April 14, 2023

RE: SE-23-00007 Bowers Field - Notice of Application

Washington State Department of Transportation Aviation Division (WSDOT-AD) appreciates your engagement with our office concerning construction plans near airports. Due to the proximity of the proposed SE-23-00007 to the Bowers Airport, we reviewed the application materials in reference to WSDOT-AD's Airport Land Use Compatibility Program. This program addresses elements of safety, airspace hazards, noise, and land use in relation to public use airports. WSDOT-AD is concerned with the safety and compatibility of the placement of this project. Specifically, we are concerned that the mitigation enhancements may increase the attraction of wildlife in close proximity to aviation operations.

**BOWERS FIELD AIRPORT
WETLAND AND STREAM MITIGATION PROJECT
FIGURE 2 - PROJECT PLAN**

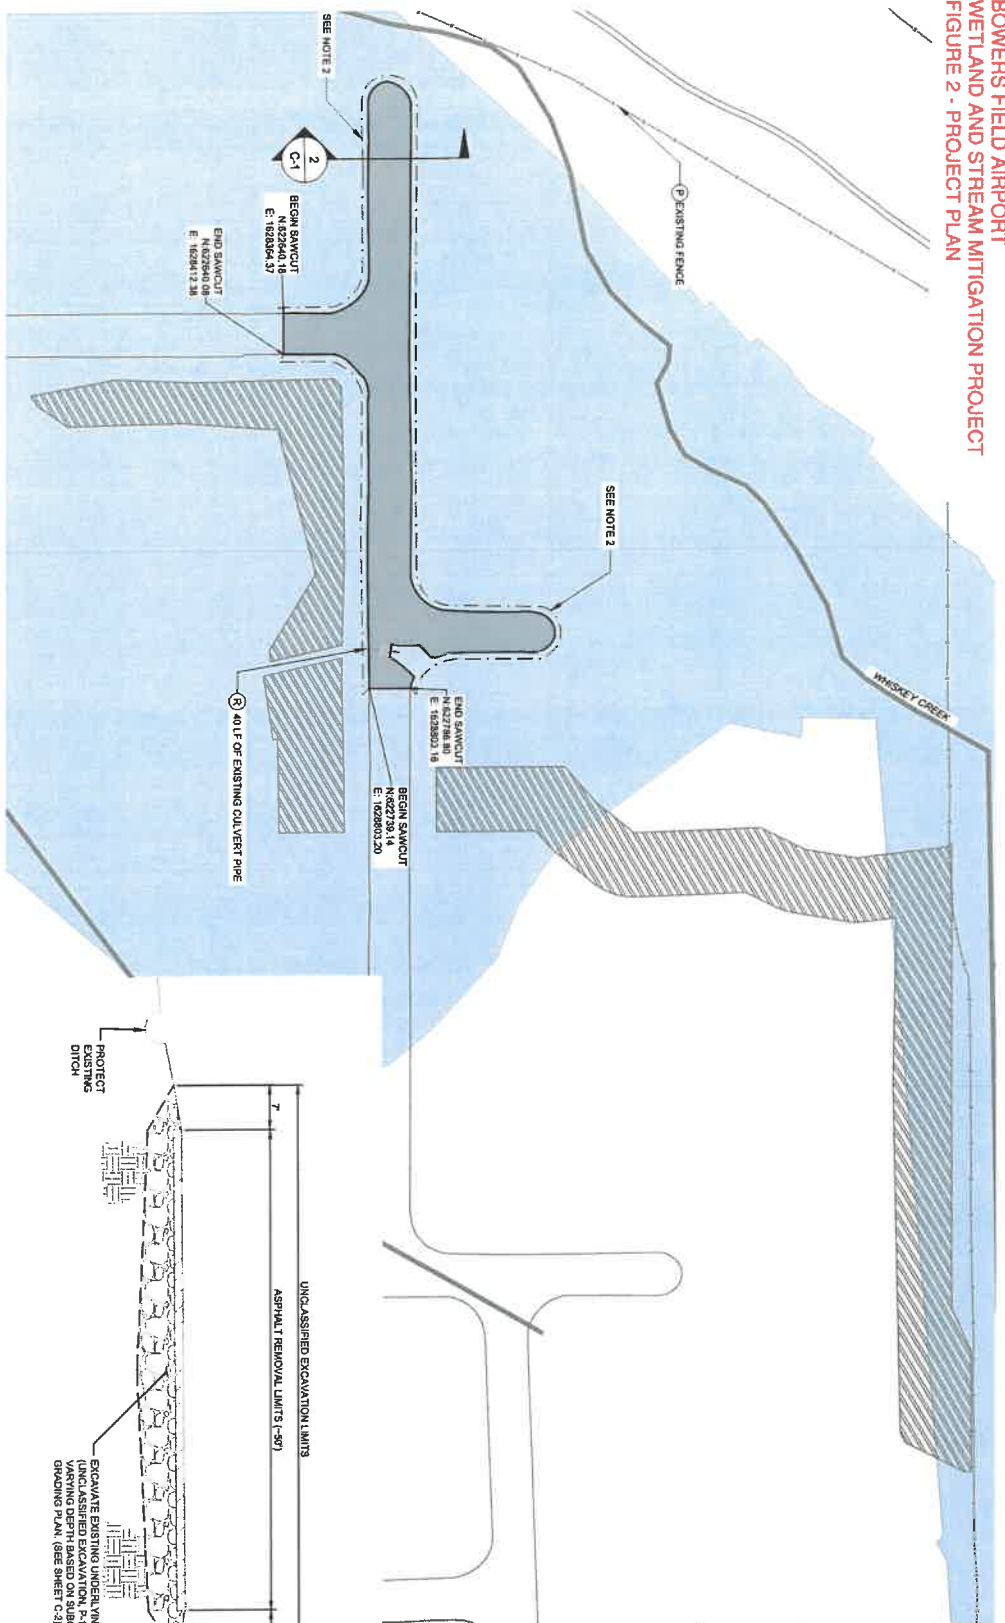
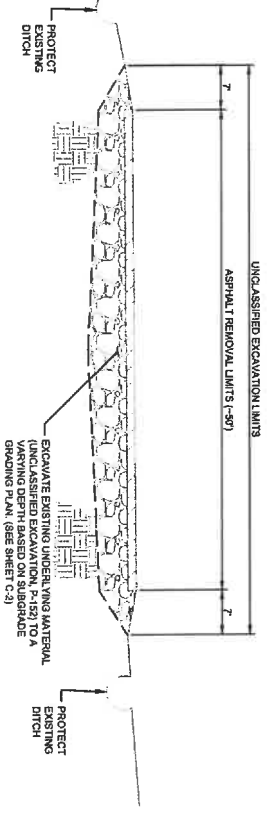
Because this airport has special approach procedures specifically designed to accommodate aircraft in poor weather conditions, "the FAA recommends a distance of 5 miles between the closest point of the airport's aircraft operations area and the hazardous wildlife attractant." While we recognize that this standard is quite conservative, the lower standard "for airports serving turbine-powered aircraft [such as Bowers], the FAA recommends a separation distance of 10,000 feet from these airports for any of the hazardous wildlife attractants"¹ would still be applicable. The eastern most boundary of the project appears to be approximately 1,600 feet west of the aircraft operations area and adjacent to the approach and departure paths of runways 11/29.

In Chapter 2 – Land-use Practices On or Near Airports that Potentially Attract Hazardous Wildlife, section 2.4, the AC specifically discusses existing wetlands on or near airport property as well as mitigation of wetland functions both onsite and offsite of the airport. Because this project appears to broaden the coverage of wetlands, it is critical to consider that “enhancing such mitigation areas to attract hazardous wildlife must be avoided” and all parties should implement “enhancement plans that would not worsen existing wildlife hazards or create such hazards.”

Additionally, the FAA requests early coordination as they will need to review any mitigation proposals for compatibility with aviation safety and airport operations. This coordination is mandatory due to existing airport Federal grant obligations. The AC also states that “a Qualified Airport Wildlife Biologist should evaluate any wetland mitigation projects... [and] a wildlife management plan should be developed to reduce the wildlife hazards.”² For your reference, applicable FAA Northwest Mountain Region Airport Division contact information can be found [here](#).

For assistance with minimizing the potential for wildlife attraction in this project, WSDOT-AD provides resources in its [Airport Stormwater Manual](#). Suggestions concerning wildlife planning are outlined in Chapter 3. Ideas include planting design and plant species selection within the improvement area. Appendix A of the manual lists recommended plants for airports east of the Cascades as well as species identified as inappropriate for use in airport settings.
